SOUTH HOLLAND DISTRICT COUNCIL

Purpose: To consider Planning Application H16-0207-21

Description: Proposed 20m Phase 8 Monopole C/W wrapround cabinet at base and associated ancillary works

Location: Wygate Park Spalding

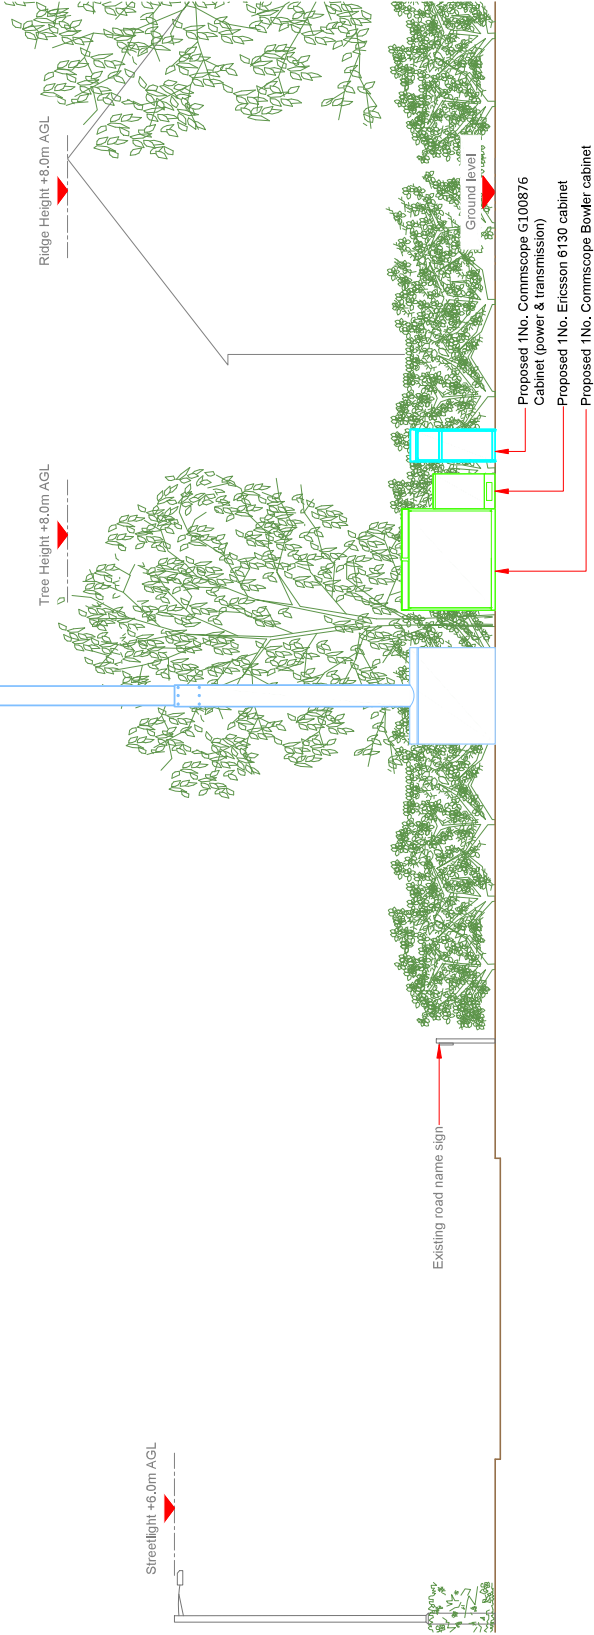
- 7.12 In terms of its siting, the proposed monopole, at 20 metres in height, would be readily visible in the street scene and the scale is not comparable to any other structure or building in the vicinity. It would be visible at a distance on Wygate Park from a westerly direction and would be well above the tree line and roof line of properties in the vicinity. The mast would be sited almost immediately adjacent to a well-used footway and would therefore be visually obtrusive to pedestrians, as well as motorists. Whilst it is accepted that there is other street furniture in the vicinity (such as street lights, road signs and post boxes), it is considered that the proposed mast and associated cabinets would have a material adverse impact on the wider street scene due to them being an unduly dominant, obtrusive and alien feature within the street scene. In light of this, the proposal is considered to be unacceptable in terms of its siting and contrary to Policies 2 and 3 of the South East Lincolnshire Local Plan (2019). Policy 2 of the Local Plan requires development proposals to take into account sustainable development considerations such as: size, scale, layout, impact on character and appearance of the area and the relationship to existing development. Policy 3 requires development proposals to respect the scale and massing of neighbouring buildings and the landscape character of the location.

- 7.20 It is considered that the proposal, by virtue of its siting, would represent an unduly dominant, obtrusive and alien feature within the street scene. Accordingly, the proposal would result in unacceptable harm to the character, appearance and visual amenity of the surrounding area which is contrary to Policies 2 and 3 of the South East Lincolnshire Local Plan (2019).

1. The proposal, by virtue of its siting, would represent an unduly dominant, obtrusive and alien feature within the street scene. Accordingly, the proposal would result in unacceptable harm to the character, appearance and visual amenity of the surrounding area which is contrary to Policies 2 and 3 of the South East Lincolnshire Local Plan (2019).
